CITY OF ALBUQUERQUE

September 19, 2023

Re: Padilla Silva Velasquez
624 3rd St. SW
Traffic Circulation Layout
Engineer's/Architect's Stamp XX-XX-XX (K14-D038)

TRAFFIC CIRCULATION LAYOUT

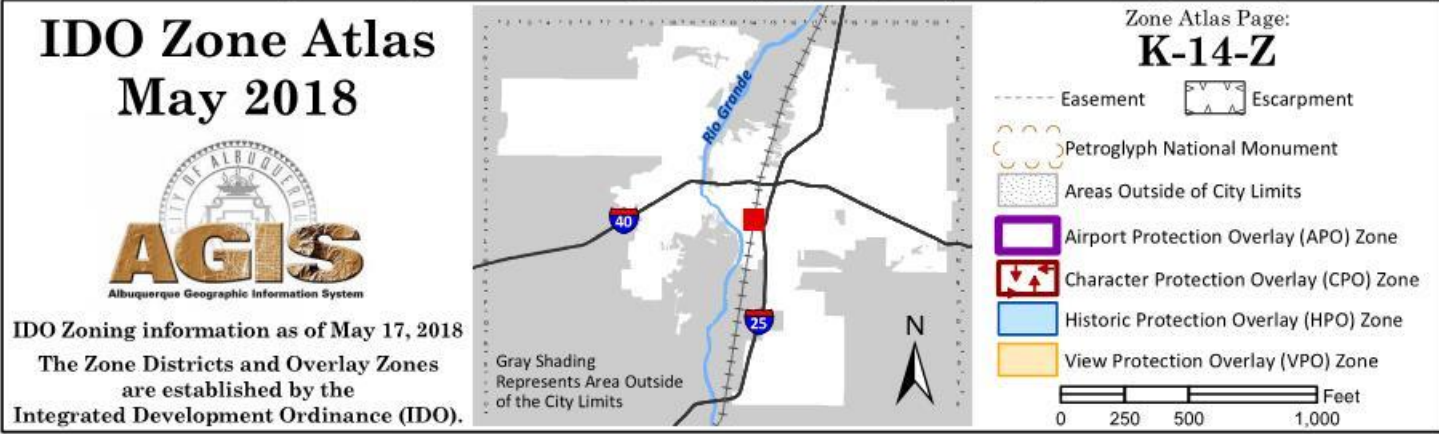
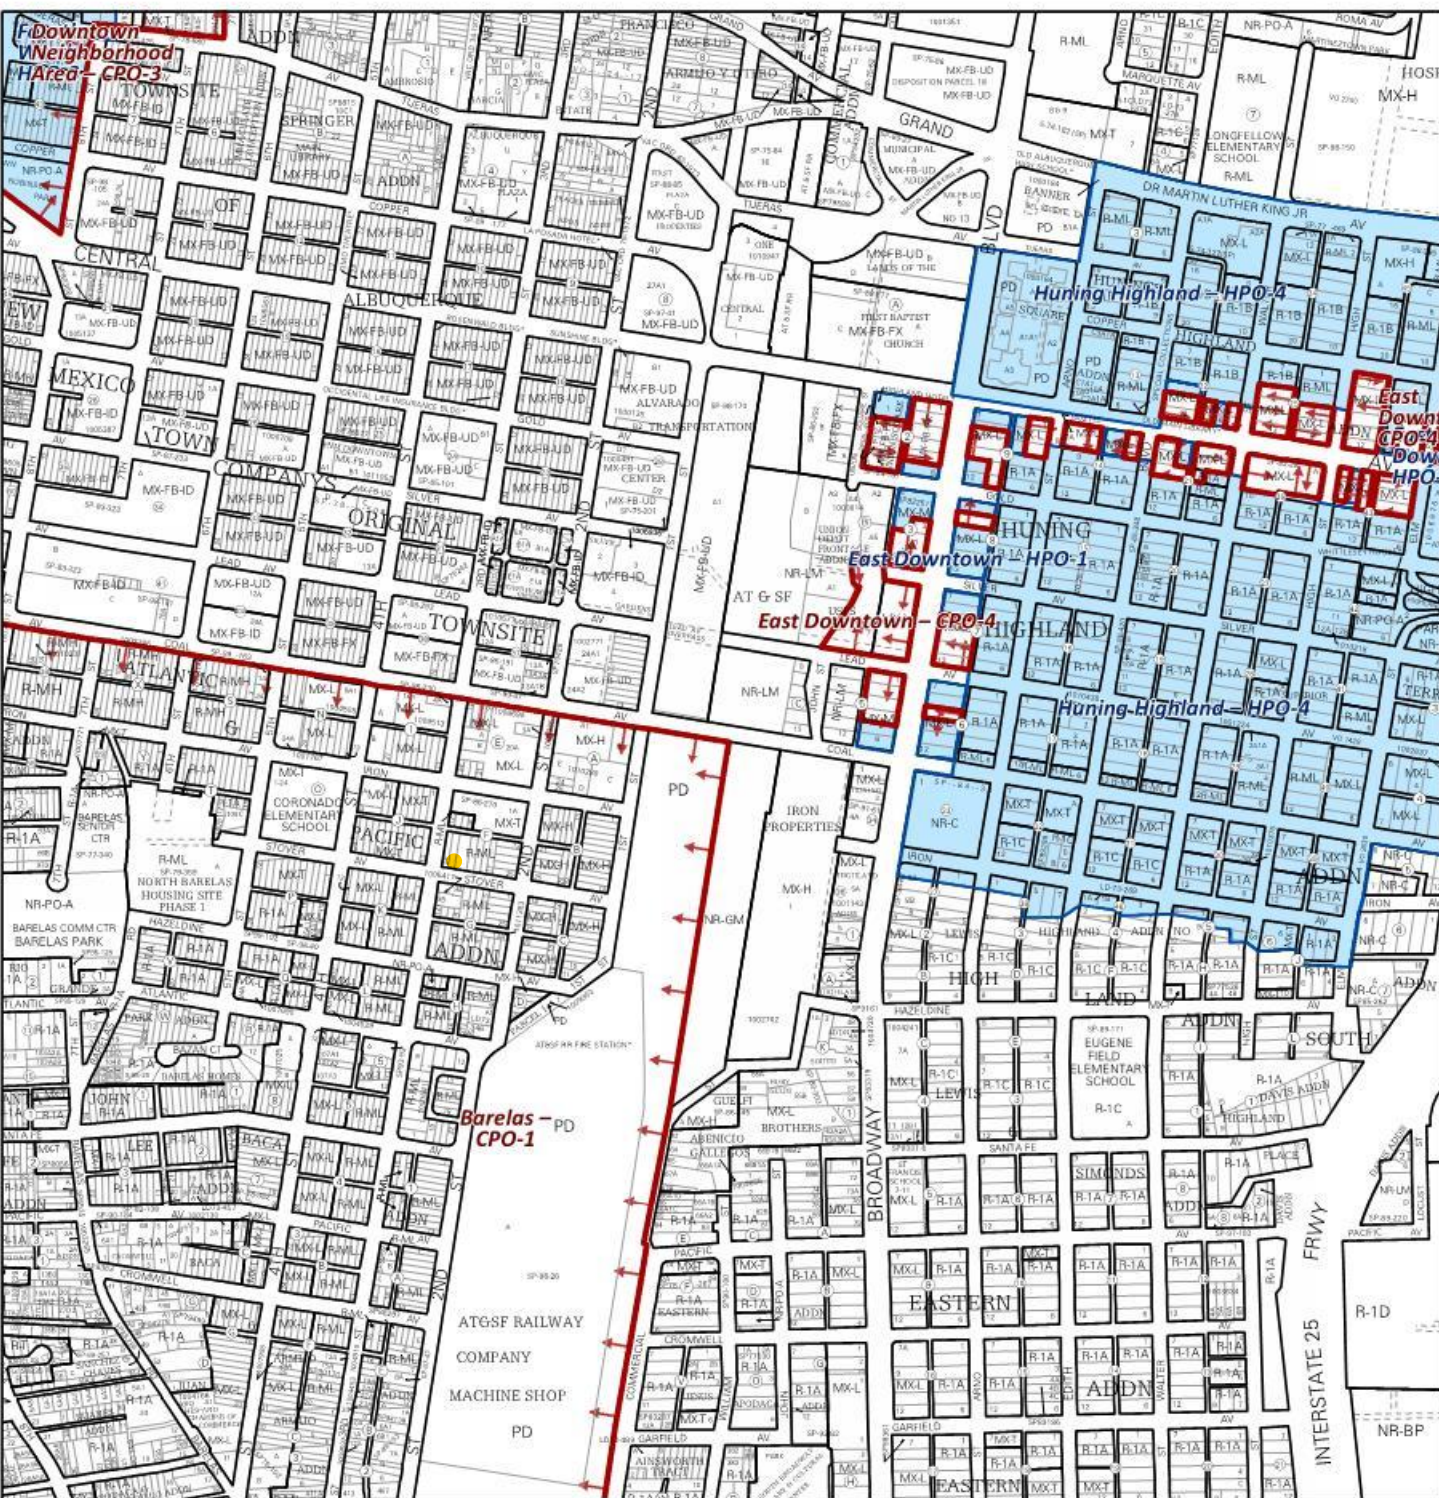
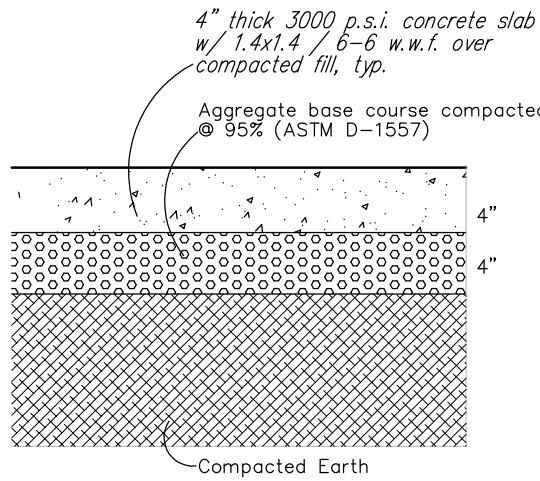
5. Minimum driveway length must be 20 ft. please revise the site plan.
6. Please reference City std dwg for the proposed 12 wide curbs cut.
7. Please show on the site plan the existing sidewalk width.

8. ADA curb ramp at the corner of 3rd St. and Stover Ave. must be updated to current standards and have truncated domes installed.
9. Unused curb cuts must be replaced with sidewalk and curb & gutter. A build note must be provided referring to the appropriate City Standard drawing.

10. Add a note stating "All broken or cracked sidewalk must be replaced with sidewalk and curb & gutter." A build note must be provided referring to the appropriate City Standard drawing.
